CMP and Windows

Tom Errico <thomas.errico@tylin.com>

Tue, Jun 5, 2018 at 1:37 PM

Drawing file: 8. Construction Management Plans / Construction Managment Plan_06-16-18.pdf

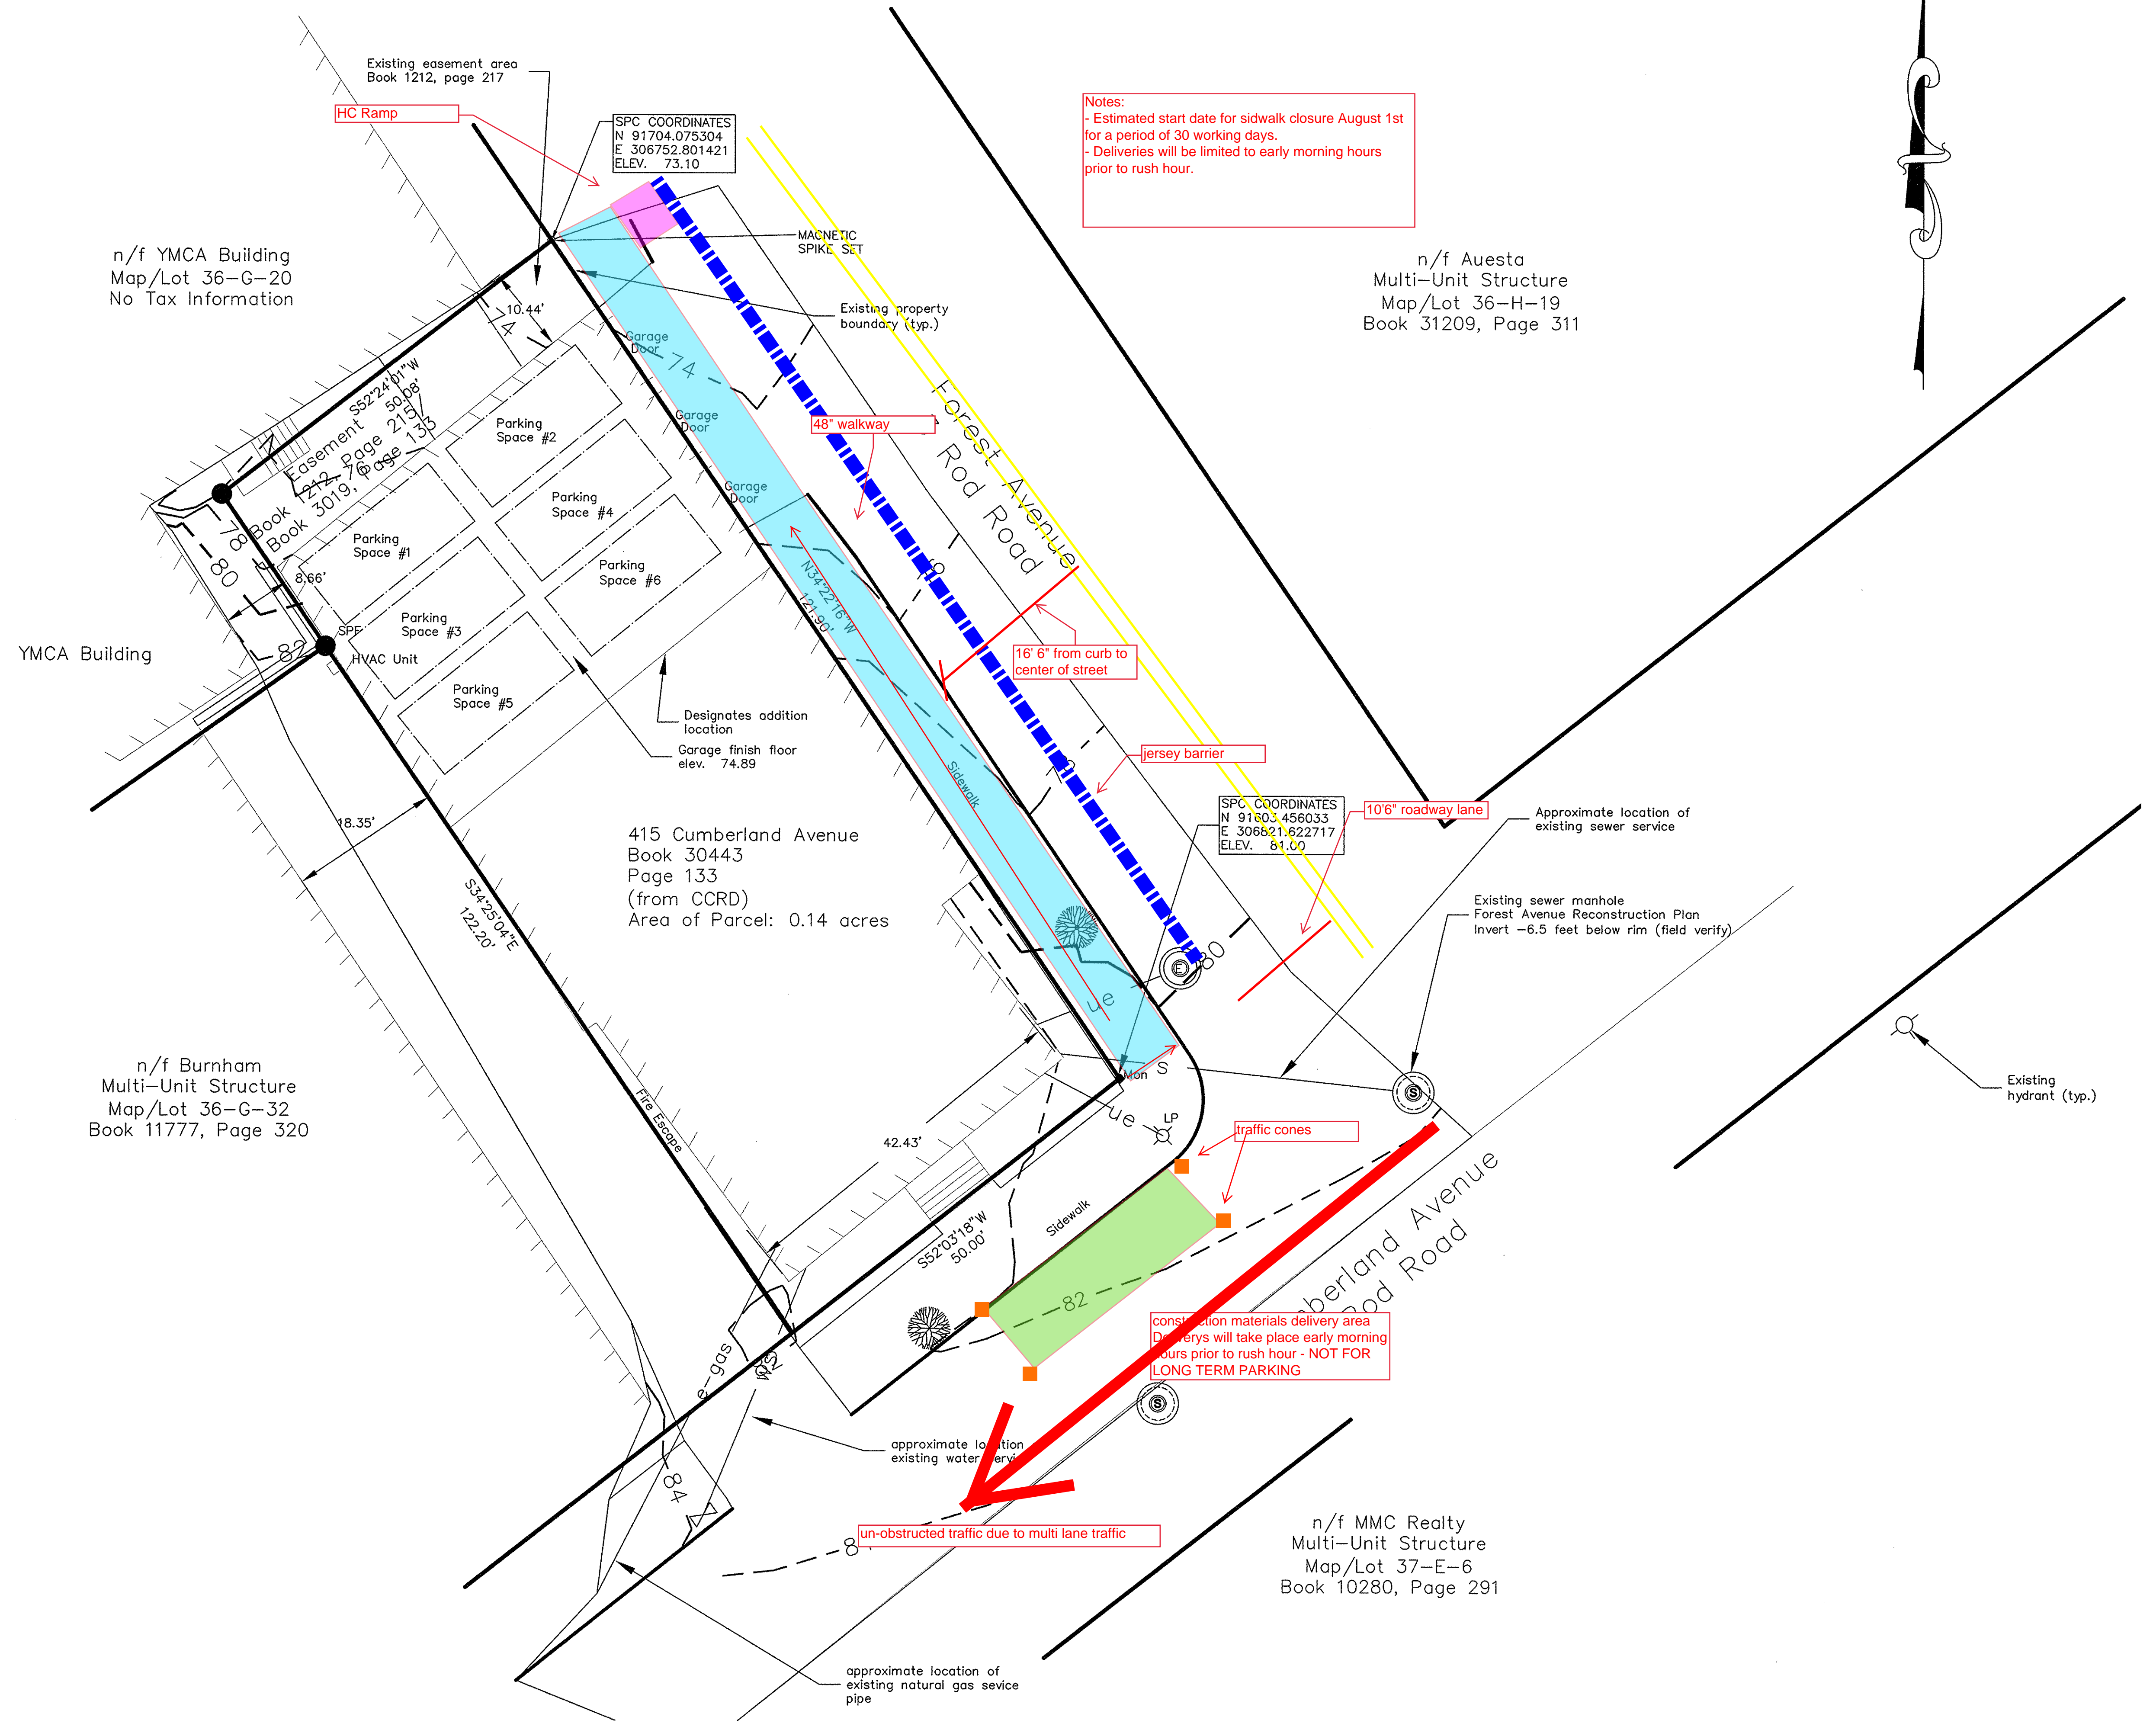
Hi Christian – the sidewalk detour plan is not acceptable. All temporary detour routes need to be ADA compliant and make sense from a use perspective. If it can fit, it may make sense to provide a temporary facility with a barrier. I would also note that DPW would like the scope and duration of the sidewalk closure to be defined. DPW does not support the occupancy of a sidewalk and/or parking for an extended period of time and construction sequences shall be scheduled to minimize the duration of any occupancy. The applicant should also provide roadway width dimensions for the vehicle loading area on Cumberland Avenue.
